Re: PA22-015 - Colvin PRD – Technical Review 1

After preliminary review of the above referenced proposal, the Planning Division has the following comment(s):

TO: Emily Morgan, Senior Planner
FROM: Brooke Ensor, NPDES Coordinator
DATE: 12/5/2022
SUBJECT: PA22-015 Colvin PRD

TO: Emily Morgan – Senior Planner
FROM: Jesse Hannahs, P.E. – Traffic Engineering Manager
DATE: December 8, 2022
SUBJECT: PA 22-015 – Colvin PRD

DRAWING TITLE:
LANDSCAPE PLAN

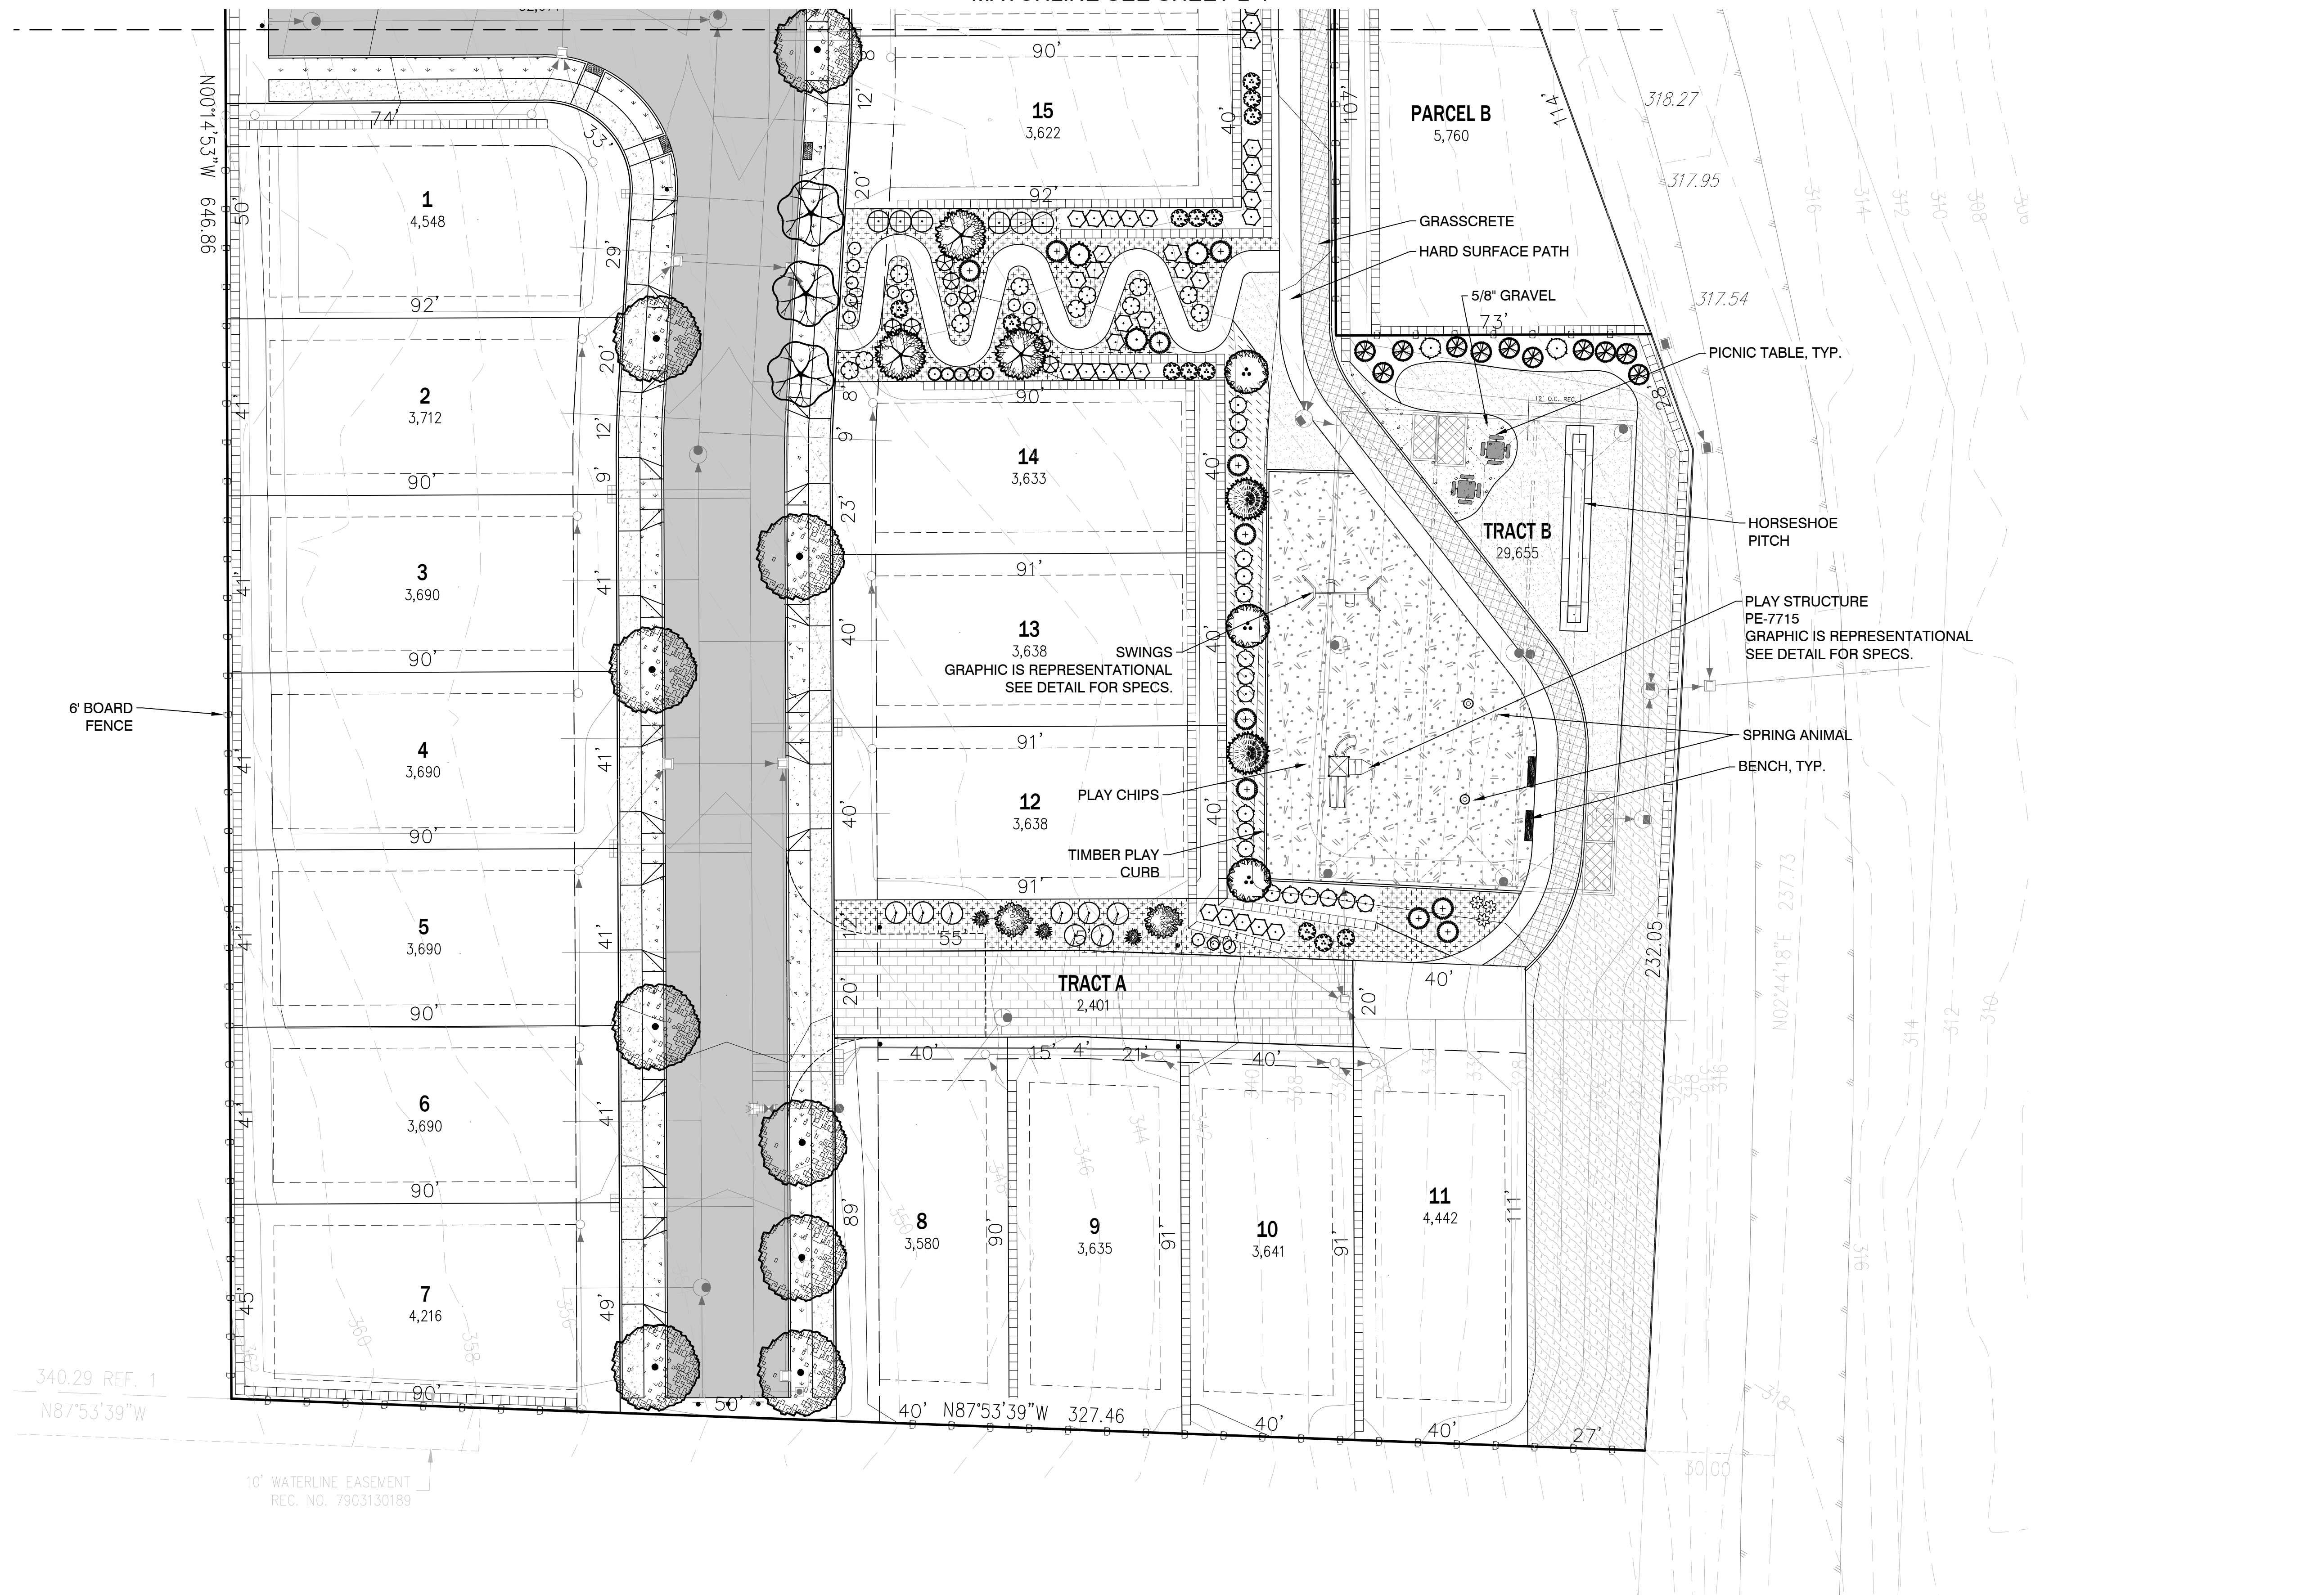
2. Per MMC 22C.120.140(2)(a), street trees are required along city streets and access easements. Update landscaping plan to include street trees along Tract C and D.

3. Based on the proposed height of the retaining wall along the east boundary adjacent to Densmore, revise landscape plan to include some landscaping, such as trees, along the base of the wall to provide some alleviation from massing.
